**WELWYN HATFIELD BOROUGH COUNCIL
ASSISTANT DIRECTOR (PLANNING)**

DELEGATED APPLICATION

Application No: 6/2023/1099/PN15
Location: Hatfield Avenue Hatfield Business Park Hatfield AL10 9FY
Proposal: Proposed telecommunications installation: Proposed 15.0m Phase 8 Monopole and associated ancillary works
Officer: Ms Jessica Fuller

Recommendation: Prior Approval Required and Granted

Title:
260 PROPOSED ELEVATION

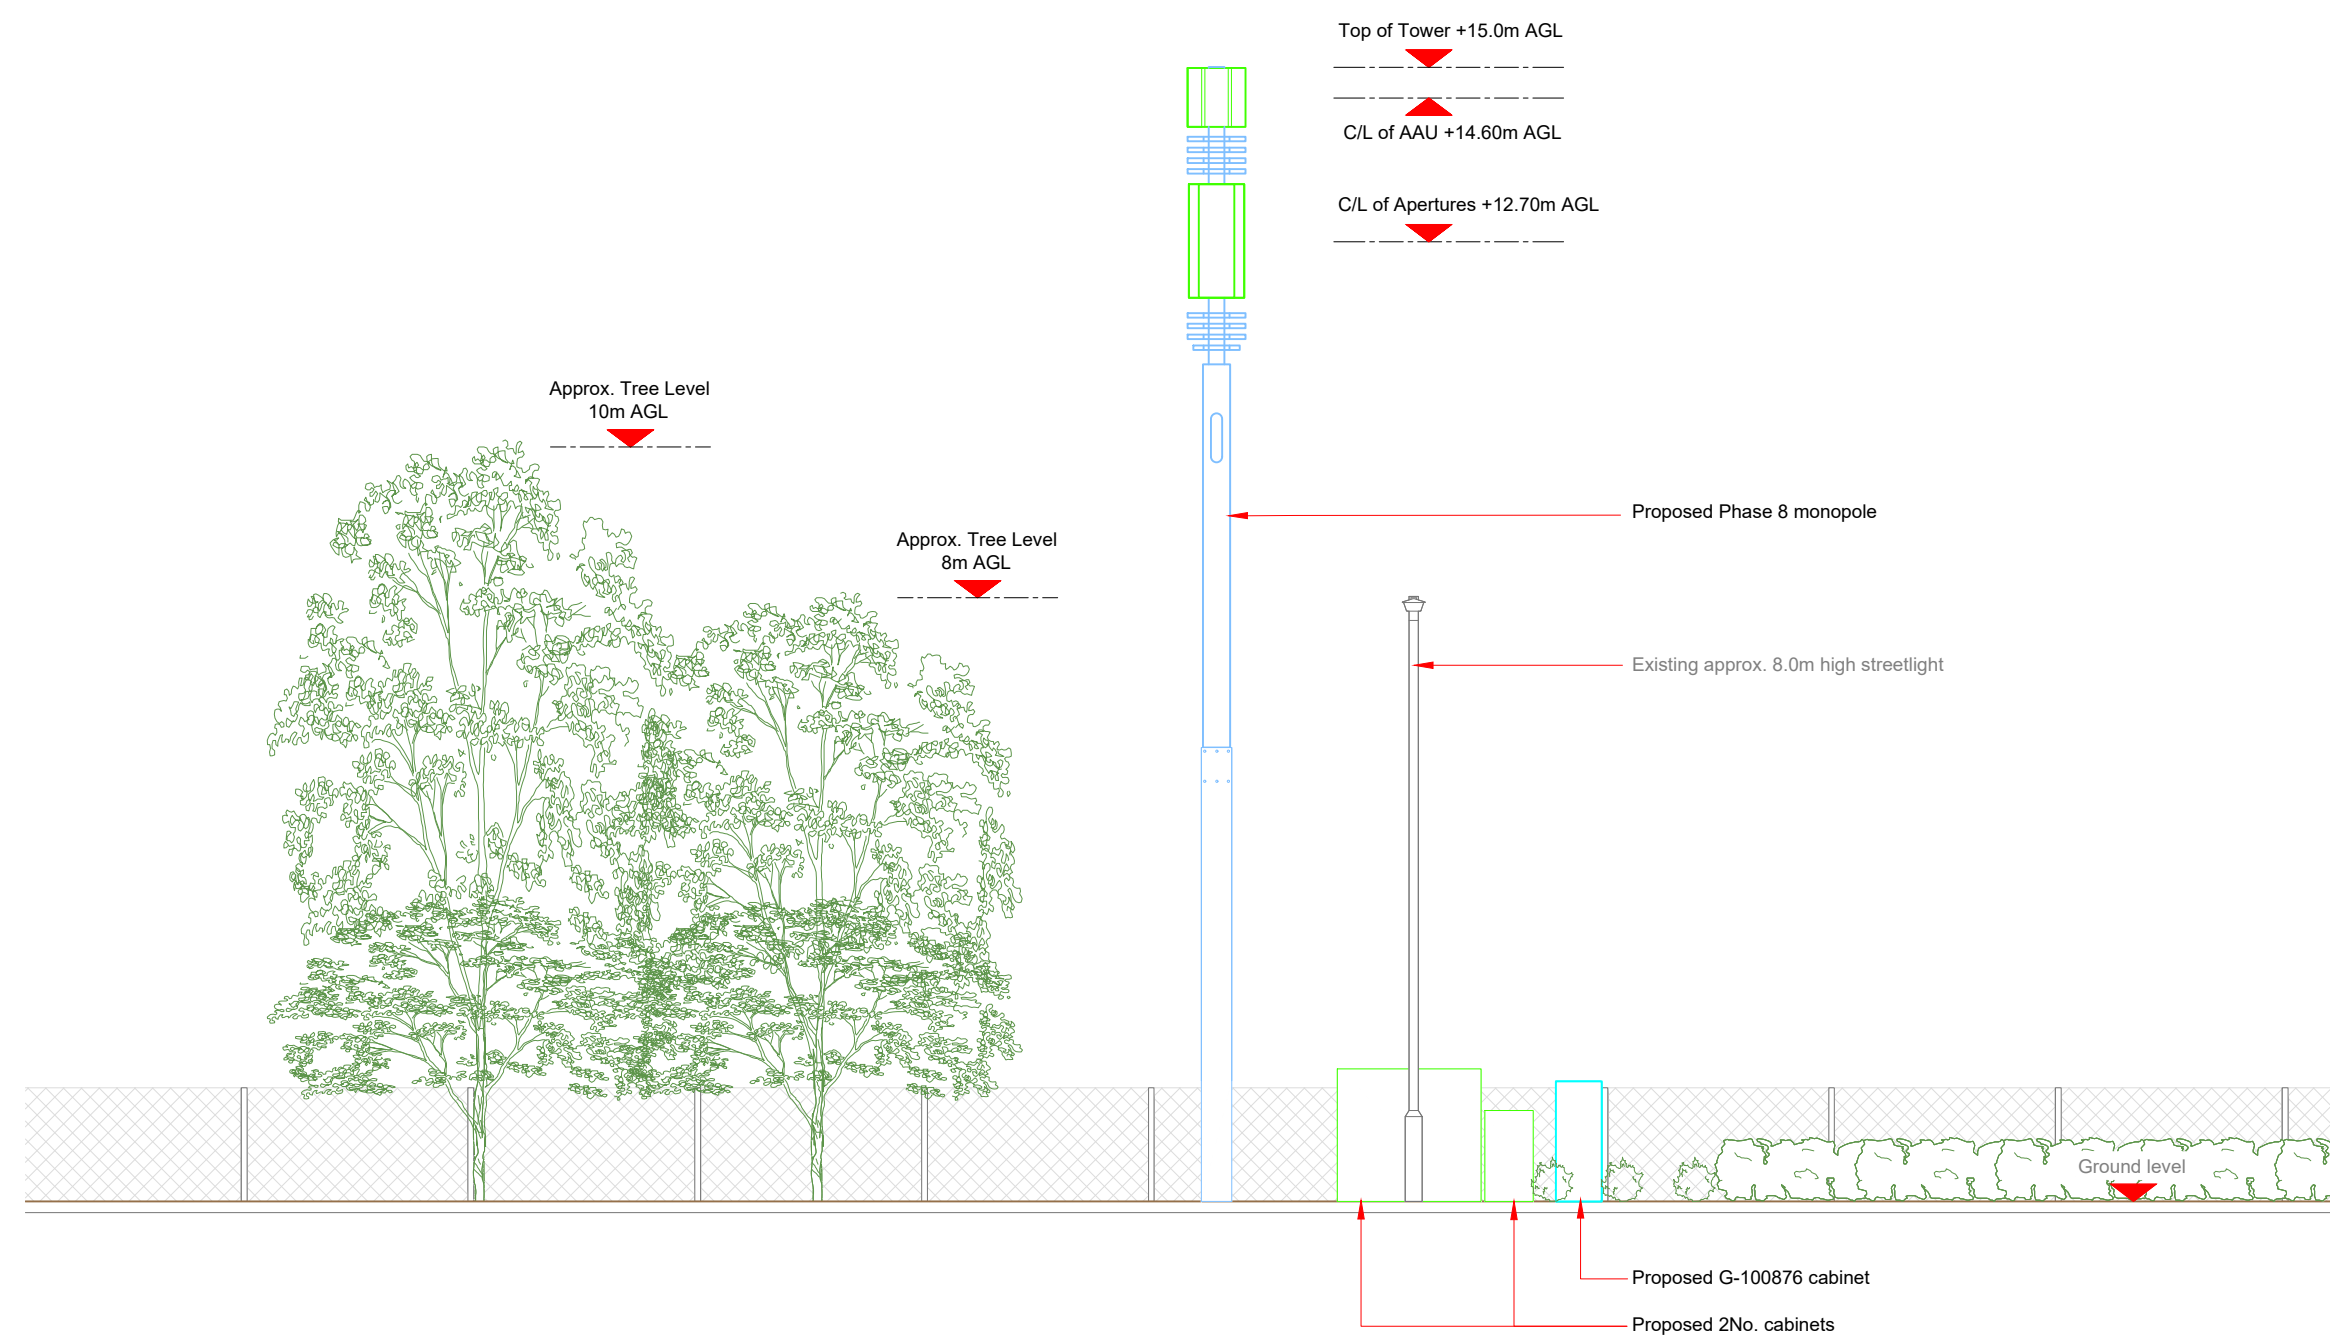
Concerns have been raised from neighbours regarding the over prominence of the mast at this location, how the mast should be shared with other masts to avoid the installation at this location, and highway safety concerns.

In terms of the over prominence of the mast at this location, the mast has been designed to be as discrete as possible whilst ensuring the provision of an adequate level of service in this area. Discussions have led to the colour of the mast changing from steel grey to fern green in order to blend with the soft landscape backing. Whilst visible from different public vantage points, the proposed monopole would generally be viewed against a backdrop of soft landscaping, thereby minimising its visual impact within the street scene. Although the development would still be prominent, this would soften its appearance and provide some screening of the telecommunications equipment such that it would not be visually intrusive to such a degree to justify a refusal of this prior approval application. A similar approach was taken by the Inspector in relation to appeal APP/C1950/W/22/3291322. Moreover, the cell search areas for 5G are extremely constrained with a typical cell radius of approximately 50m meaning that it would not be feasible to site the column outside of this locale. It is therefore considered this location is the most suitable option.

1. As agreed with the agent, the proposed monopole and associated ancillary works should be installed in Fern Green (RAL6025).
2. Obstruction of public highway land: It is an offence under section 137 of the Highways Act 1980 for any person, without lawful authority or excuse, in any way to wilfully obstruct the free passage along a highway or public right of way. If this development is likely to result in the public highway or public right of way network becoming routinely blocked (fully or partly) the applicant must contact the Highway Authority to obtain their permission and requirements before construction works commence. Further information is available via the website:

Title: **211 VIS SPLAY PLAN**

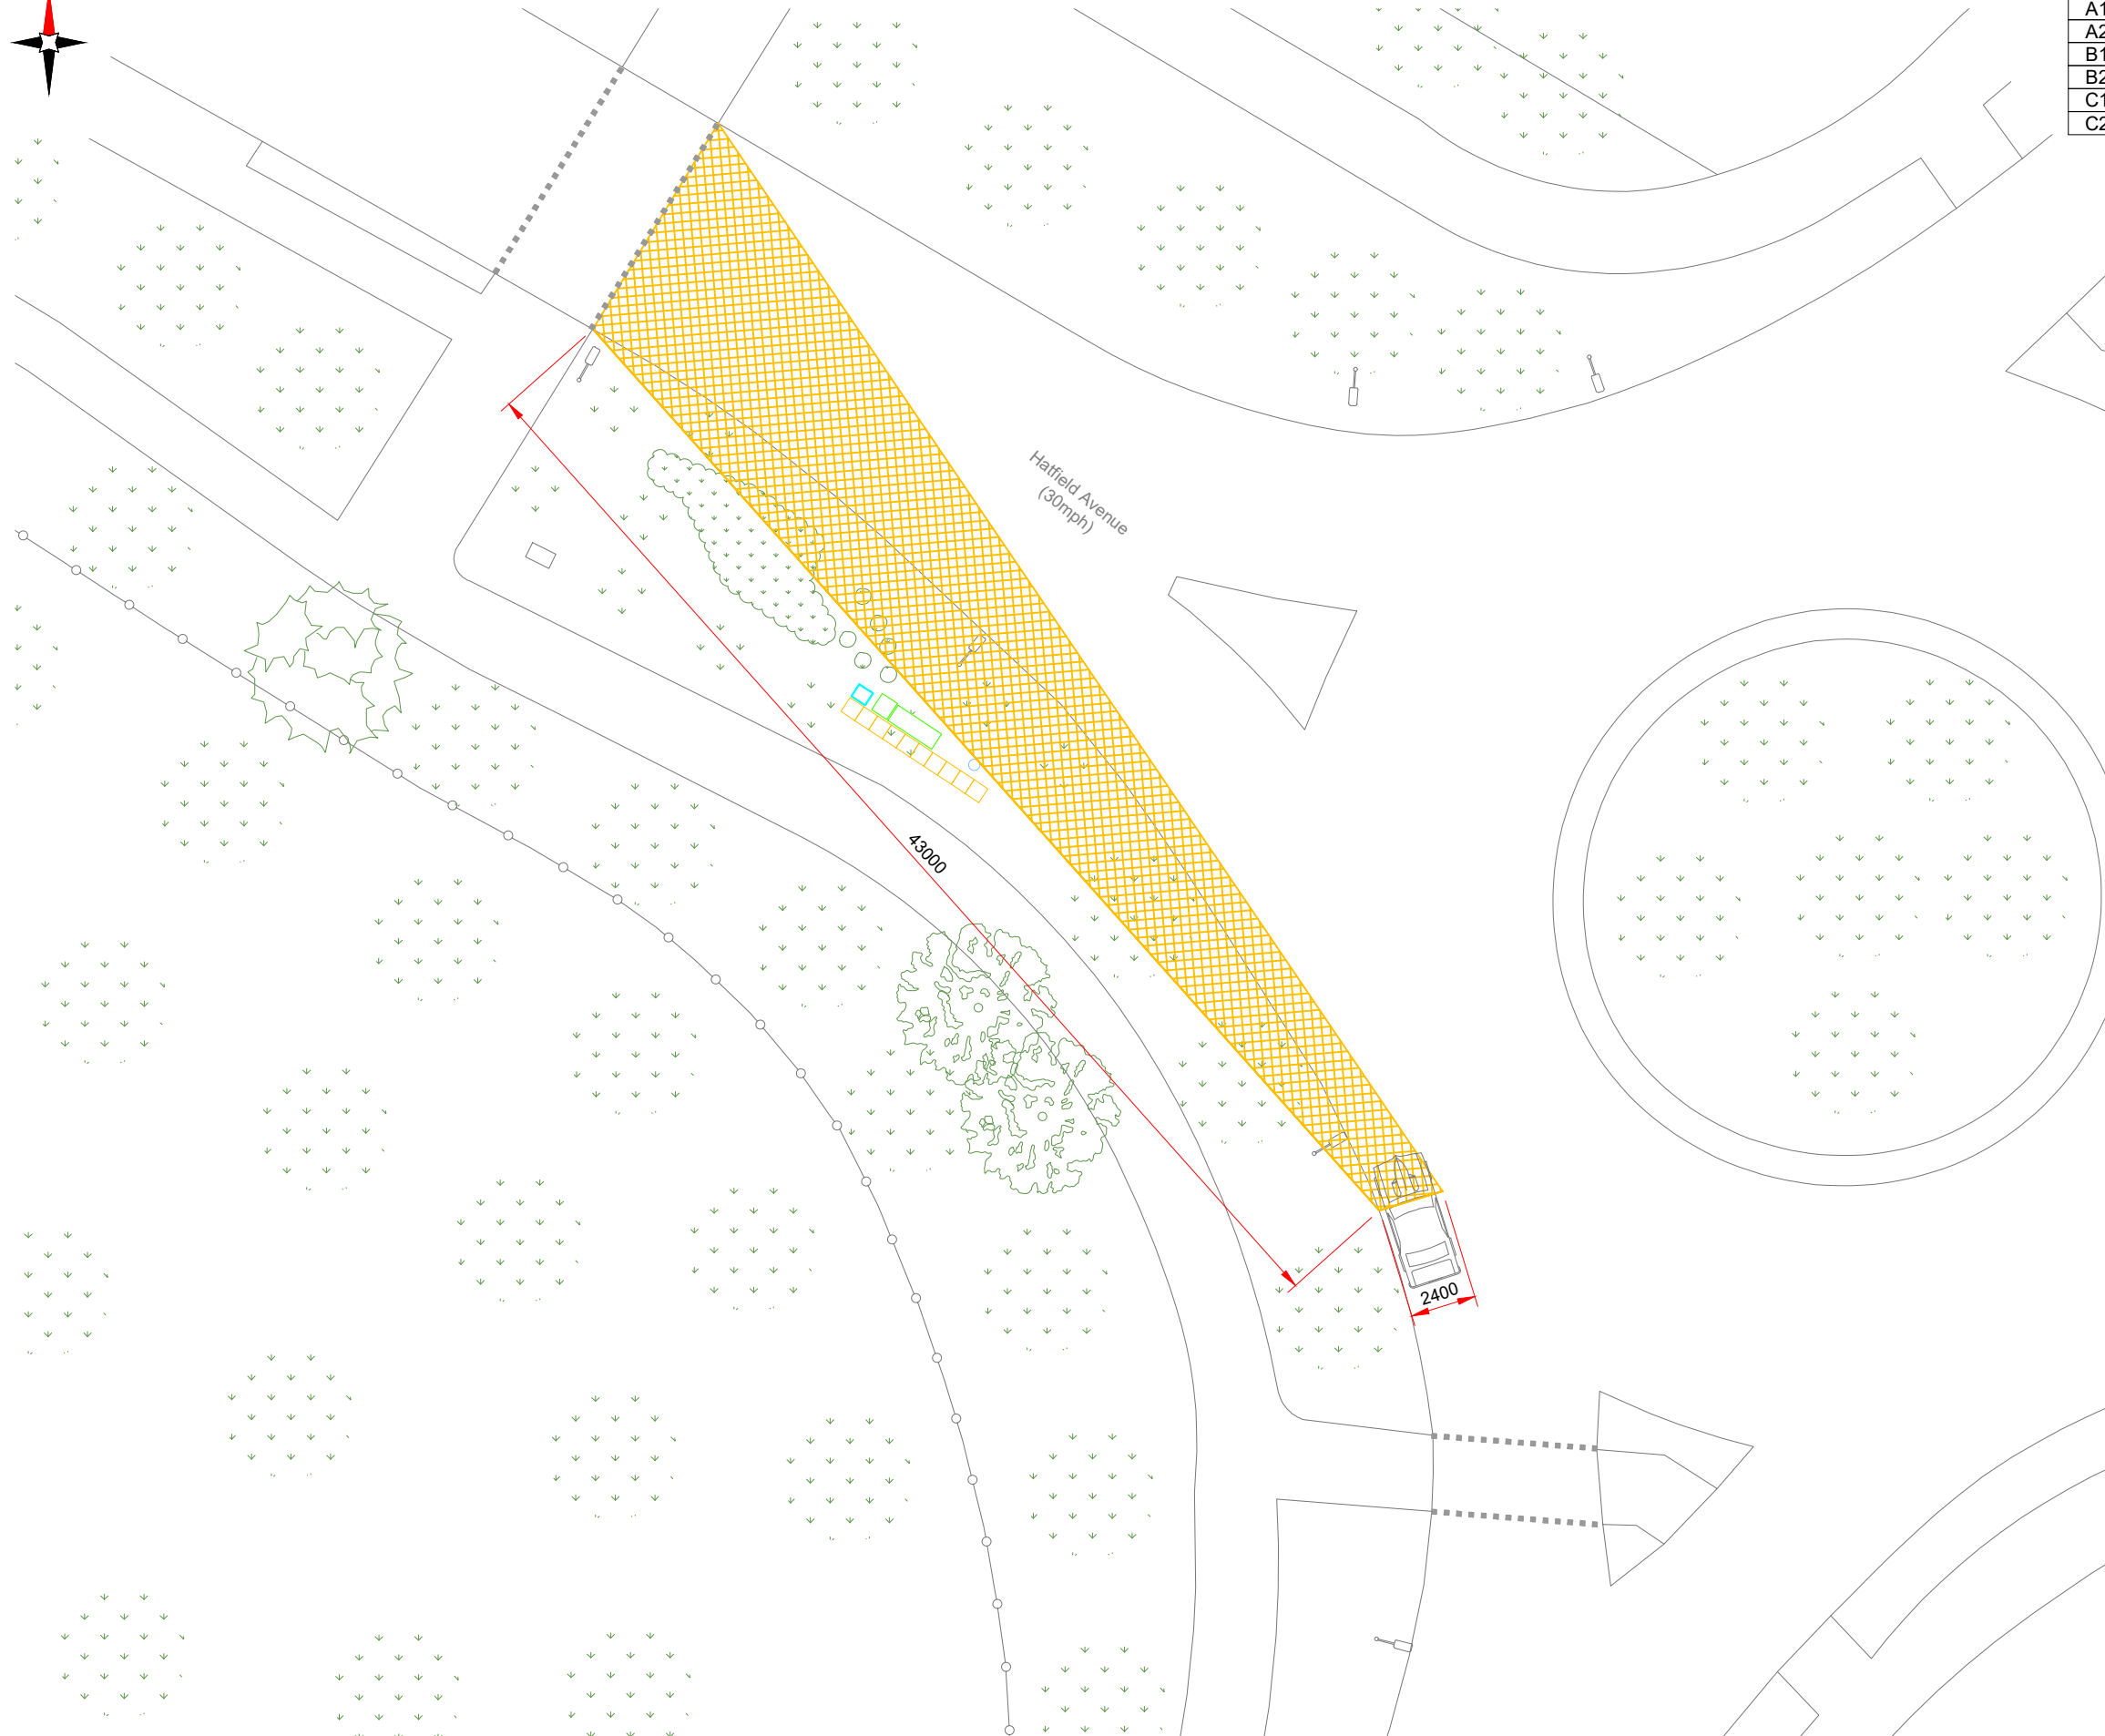
The Highways Authority have been consulted on this application, with their initial response recommending refusal due to a lack of information. The highways authority stated that no plans were submitted to demonstrate the proposed location of the works was outside the limits of visibility. The objection was with reference to the near by roundabout, meaning a visibility splay would be required in order to show how the proposed works would be outside the visibility splay of vehicles entering the roundabout from the southern arm turning left. The agent subsequently provided this information which satisfied highways concerns. Highways have since therefore removed their objection, stating that permission should not be restricted. Whilst conditions were suggested, these are not considered to meet the tests set out in the NPPF and would be controlled by highway permits outside of the planning system. On this basis, no objections are raised on highway grounds.

In terms of highway safety concerns, the Highways authority have been consulted for this application and, as previously discussed, removed their initial objection and are now satisfied that the proposal meets highways policy.
